CITY OF ALBUQUERQUE

Re: Broadstone Santa Monica, Buildings 26 & 27
Request for Permanent C.O. – Not Accepted
Engineer's Stamp dated: 04-10-12, (D18/D054)
Certification dated: 05-15-13

Based upon the information provided in the Certification received 05-15-13, the above referenced Certification is not acceptable for release of a Permanent Certificate of Occupancy by Hydrology. The following comments need to be addressed before a CO is given for phase 3.

CG1.5
RECEIVED
APR 10 2012
HYDROLOGY
SECTION
GRADING AND DRAINAGE PLAN
SE QUADRANT

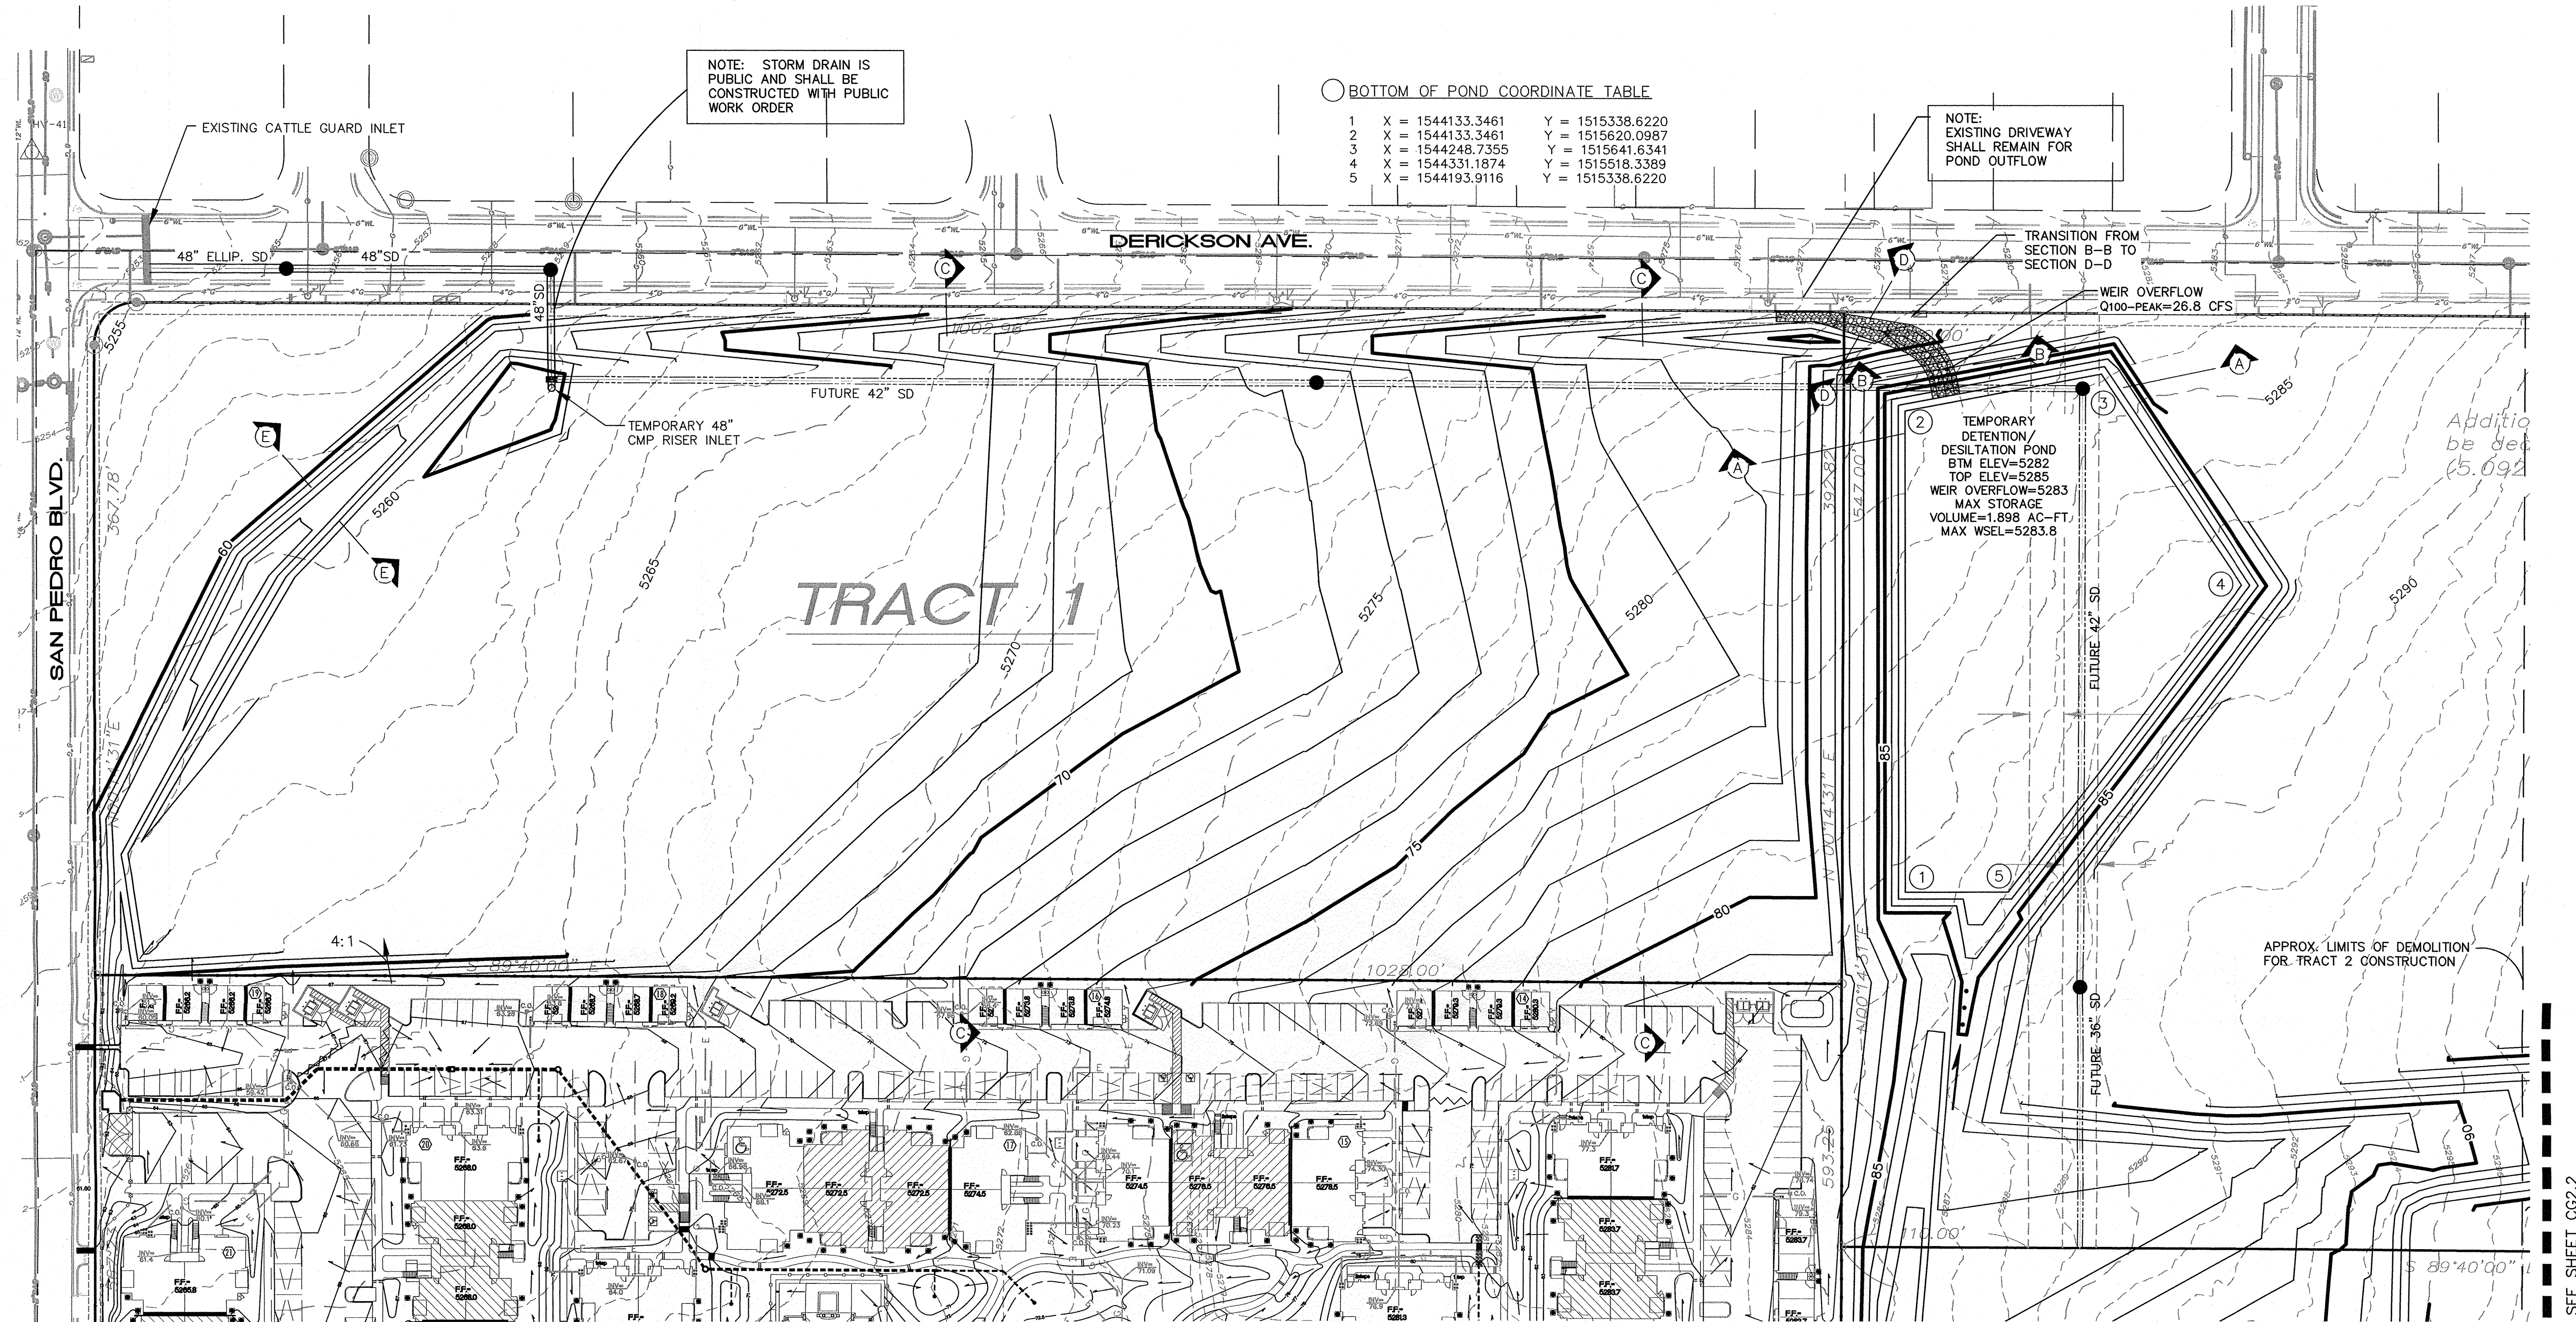
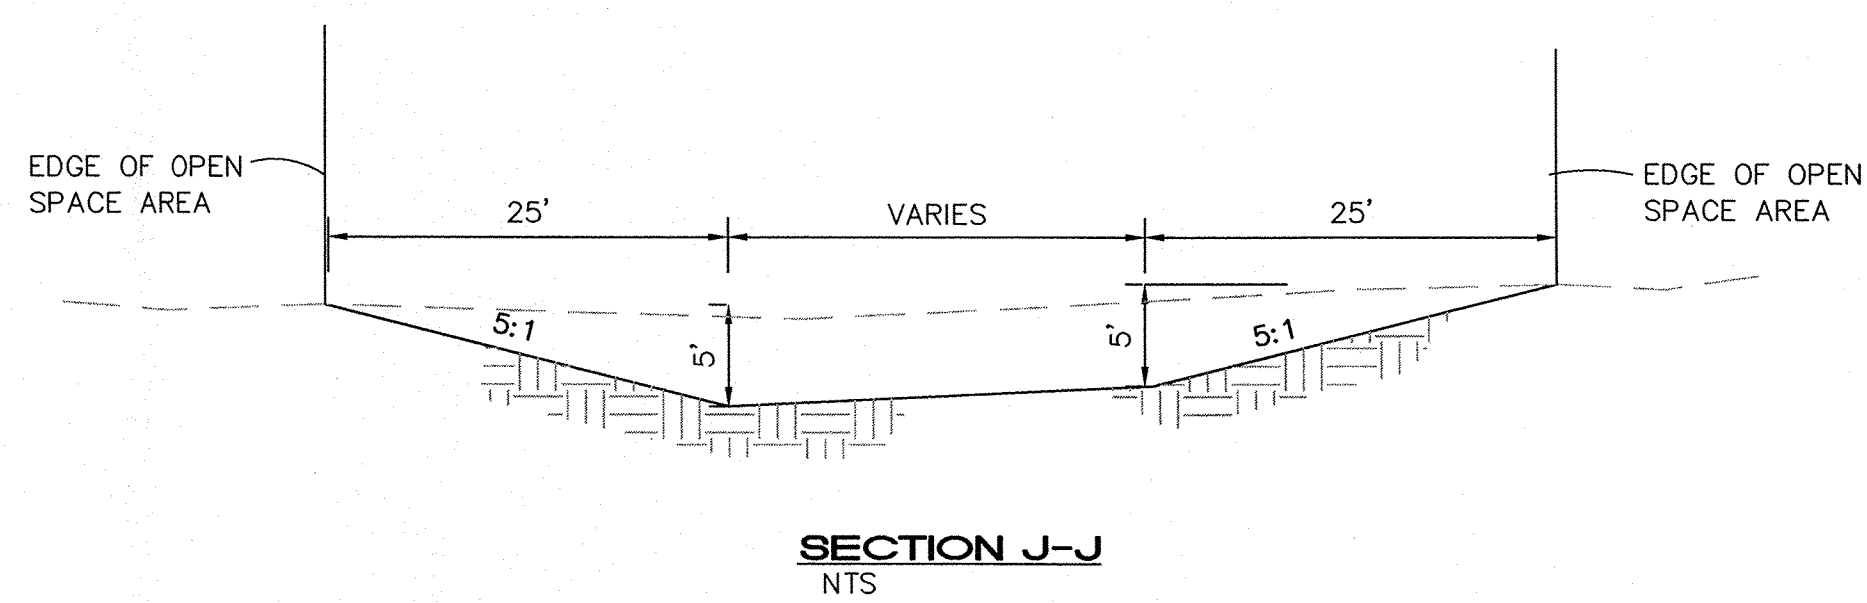
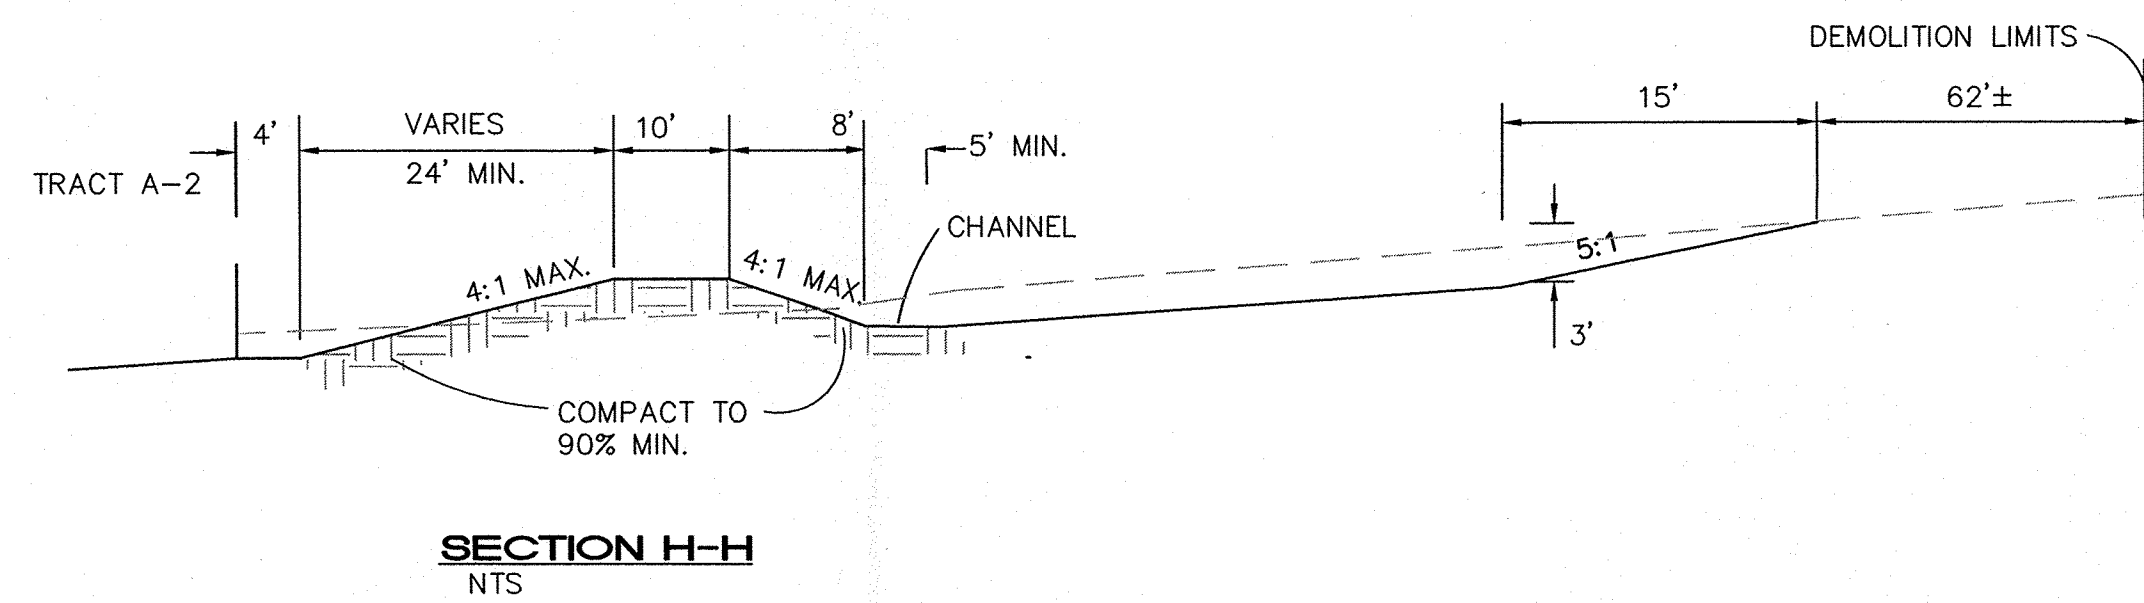
1. Include certification language and seal on sheets CG.1 and CG.2
2. The berm along Derickson Ave does not appear to be compacted to the specified 90% compaction.
3. There is a low spot at the construction entrance allowing flows to enter Derickson Ave. instead of flowing to the inlet at the NW pond. There is also a high spot just to the west of the entrance.
